Halcrow MWT

11 December 2009

**Re: RNSH Community Health Services Building
Review of Pedestrian / Vehicle Interaction at Car Park / Dock Access**

Figure 6: Extract Ground Floor Plan showing vehicular entry points.

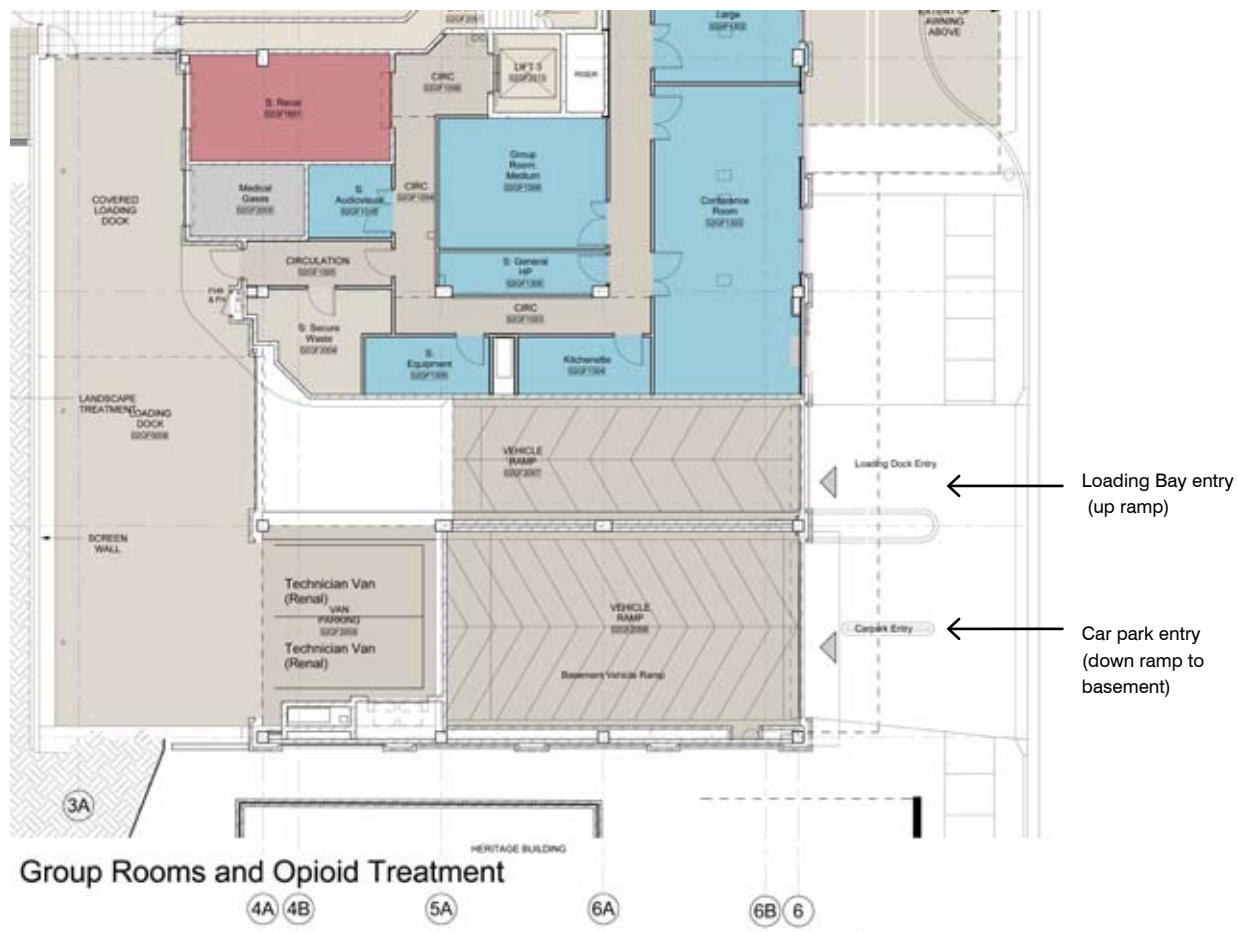
It is proposed that separate driveways will be provided for the facility servicing the basement car park and the loading dock. These driveways will be separated by a median (1.2m wide). As both these driveways cross the pedestrian path located within the road verge there will be interaction between pedestrians and vehicles entering and exiting the facility.

However for vehicles exiting the facility it is suggested that advance warning of pedestrians be provided.

Notwithstanding that the extent of vehicle / pedestrian conflicts is considered to be minimum it is recommended that advance warning signage be installed along the vehicle exit path warning drivers that pedestrian may be crossing the driveway.

It is recommended that signage read "Give Way to Pedestrians".

This advance warning signage could be roof mounted on the exit ramp provided minimum vehicle headroom requirements as specified by the consent approval are maintained.
